7 July 2020

TfNSW Reference: SYD20/00117/04

DPIE Reference: SSD 10425

**STAGE 2 MIXED USE DEVELOPMENT INCLUDING 987 RESIDENTIAL UNITS,
3000SQM COMMERCIAL, AND 6000SQM RETAIL - TALLAWONG STATION
PRECINCT SOUTH, ROUSE HILL**

60618532-SHT-00-0000-CI-0300

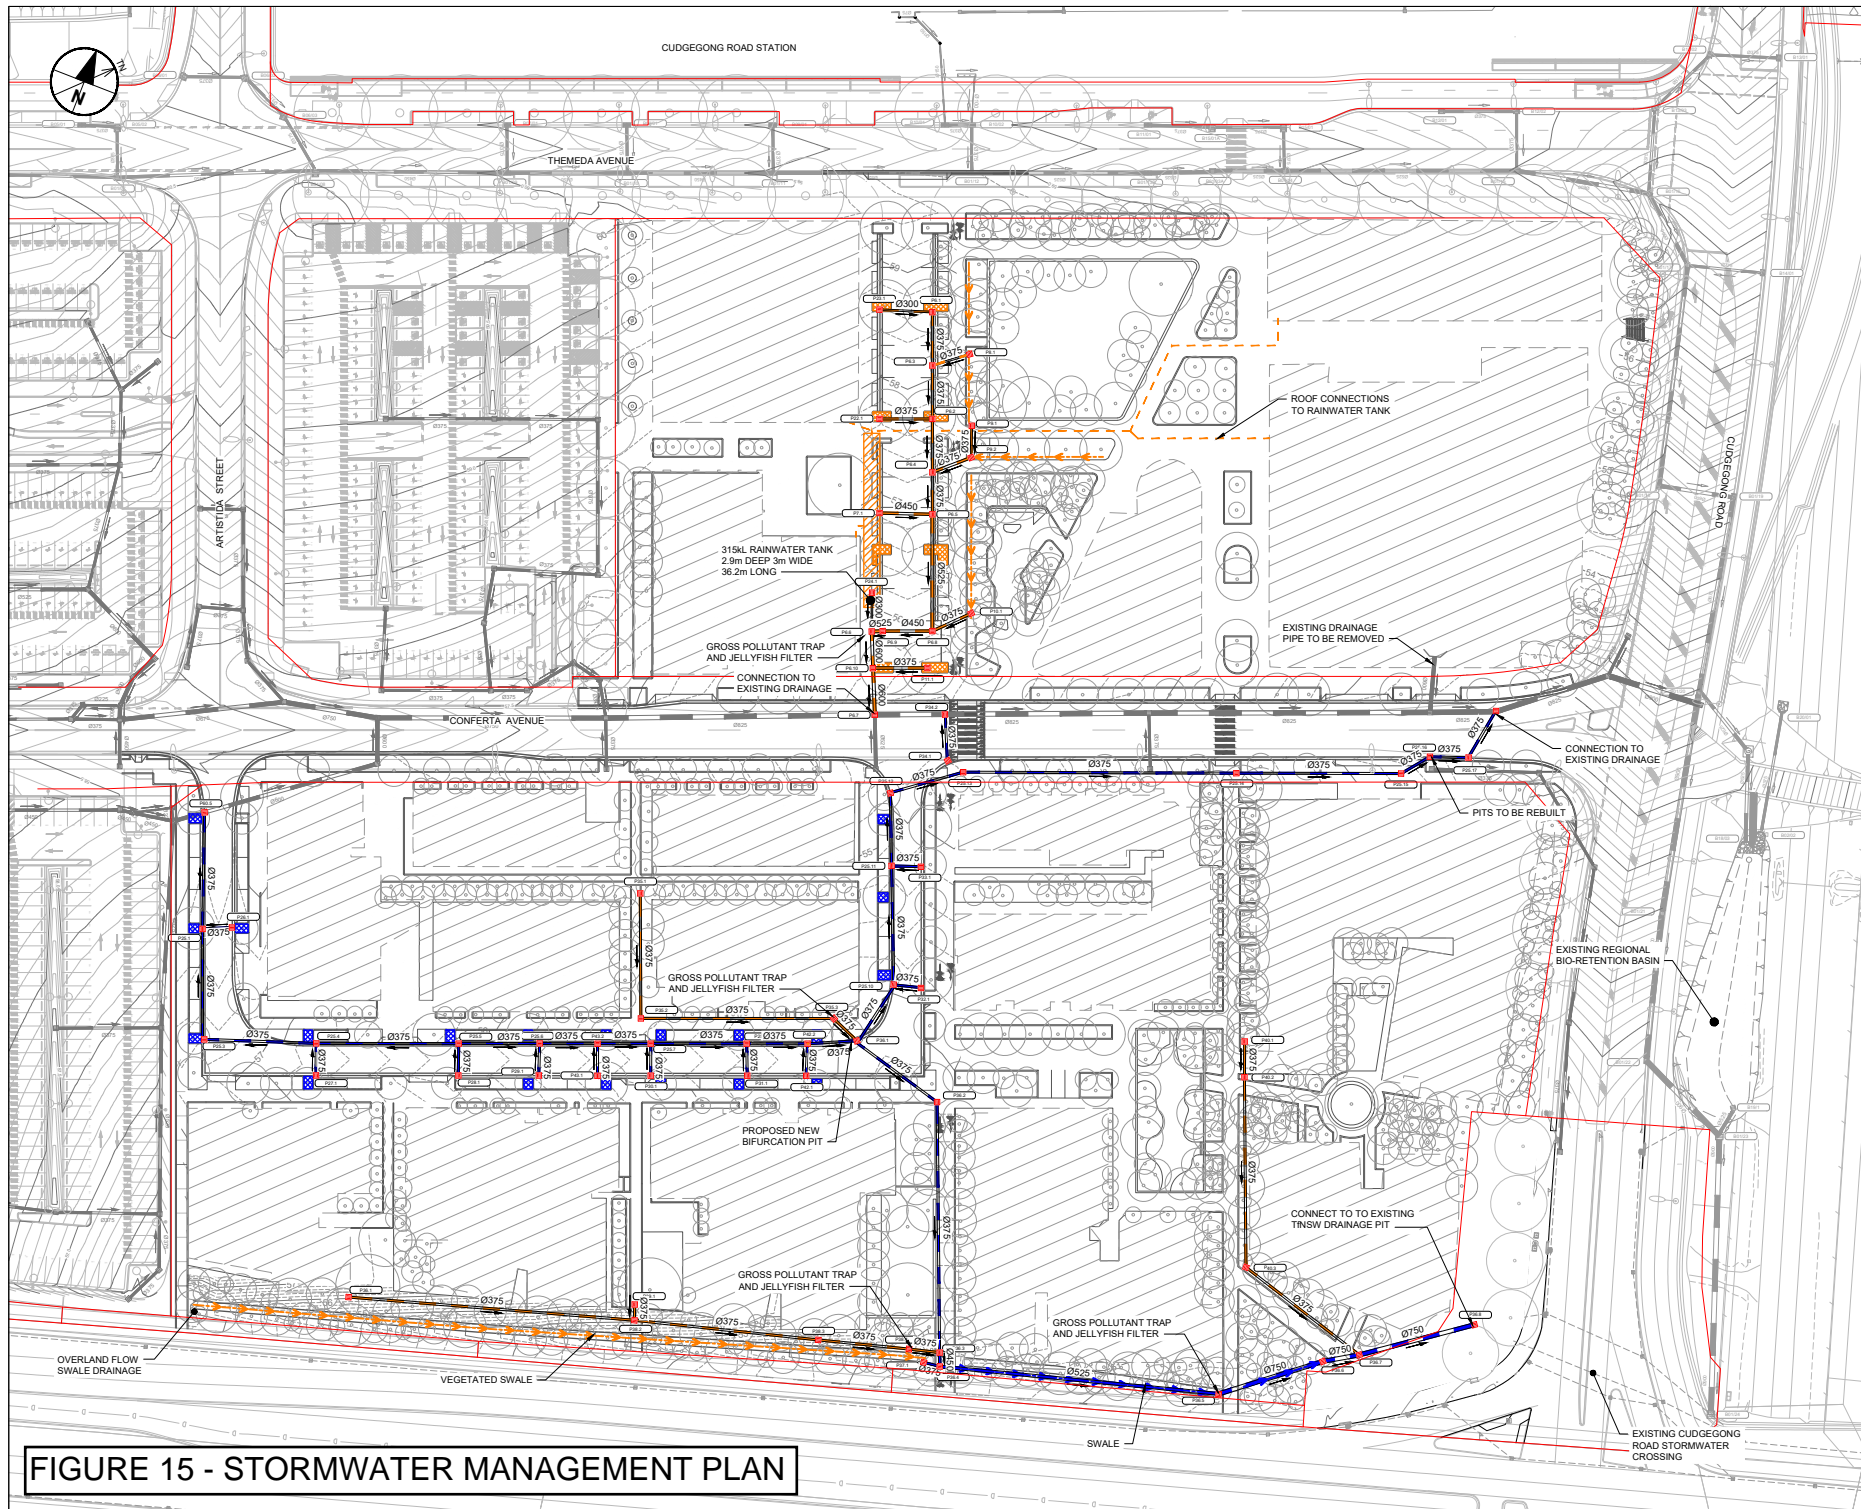
2. Any stormwater connections for this development to the existing stormwater pits located within TfNSW owned land will require the developer to contact TfNSW regarding land acquisition requirements.
3. Detailed design plans and hydraulic calculations of any changes to the stormwater drainage system are to be submitted to TfNSW for approval, prior to the commencement of any works. Please send all documentation to development.sydney@rms.nsw.gov.au.

Figure 3 Site Management Plan Site 2 (Construction Works)

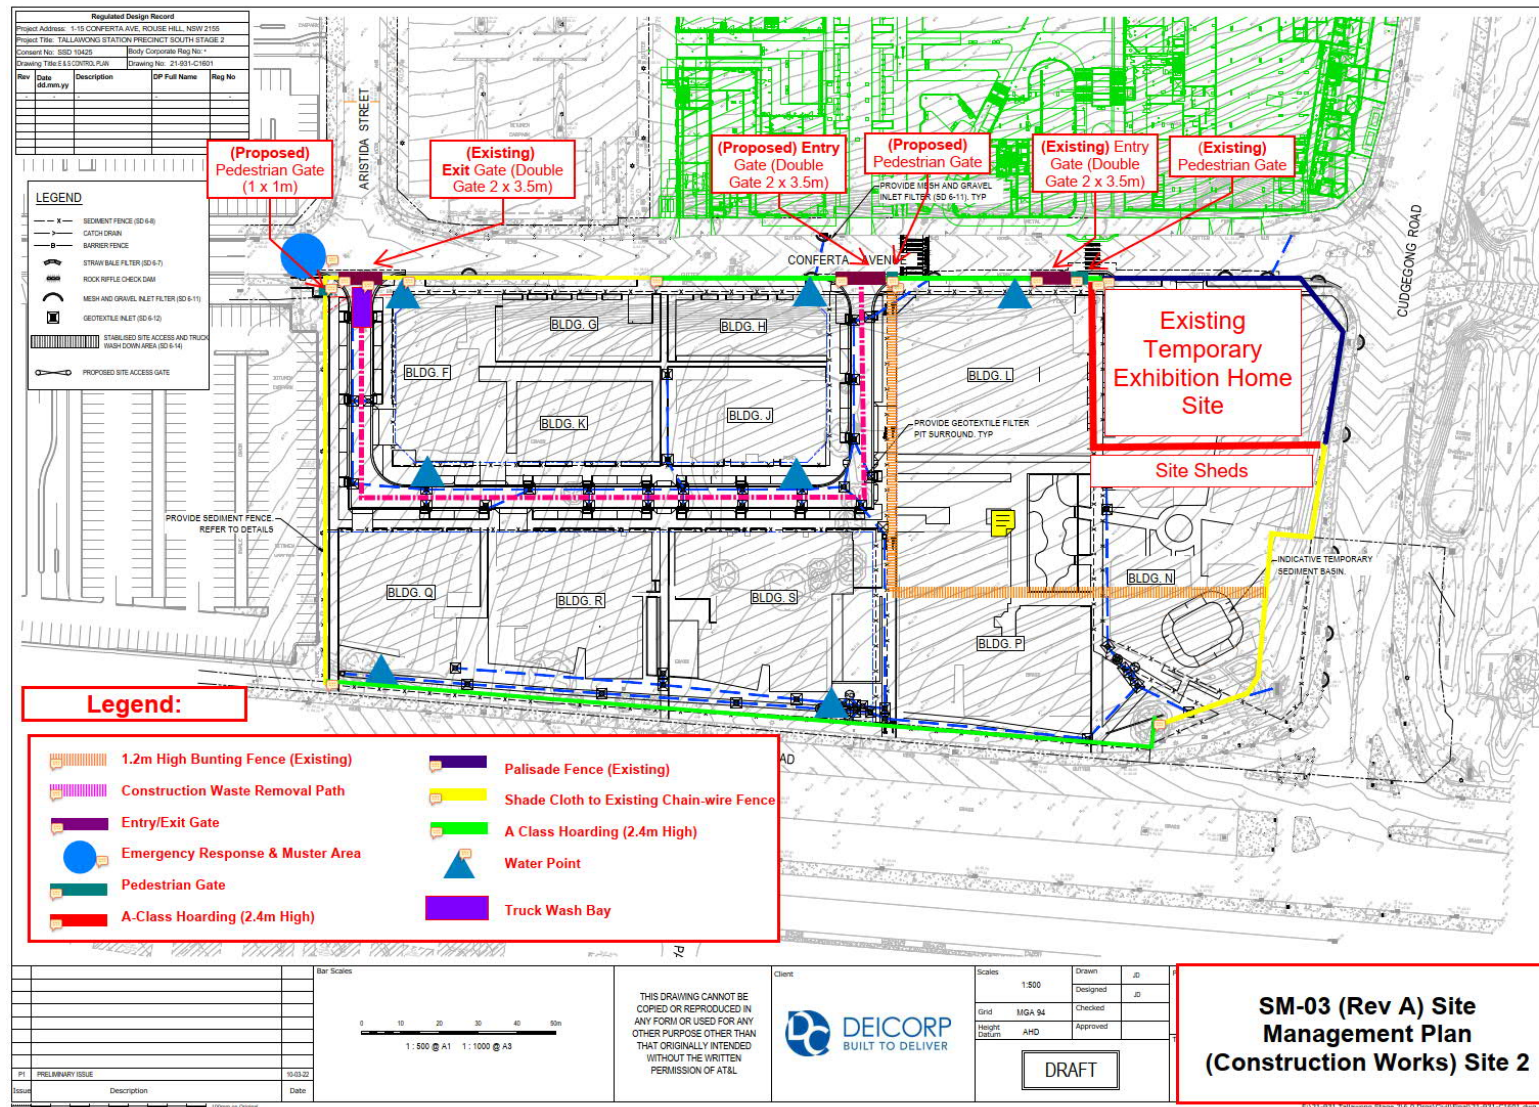
1. TfNSW has previously acquired a strip of land for road along the Schofields Road frontage of the subject property, as shown by blue colour on the attached Aerial – “X”. All buildings and structures are to be wholly within the freehold property (unlimited in height or depth), along the Schofields Road boundary.

It is noted that the submitted plans show pedestrian paths, erosion and sediment control measures such as fencing, and site office and amenities on TfNSW owned land. The plans are to be amended accordingly to ensure the development and associated infrastructure is located entirely within the development site.
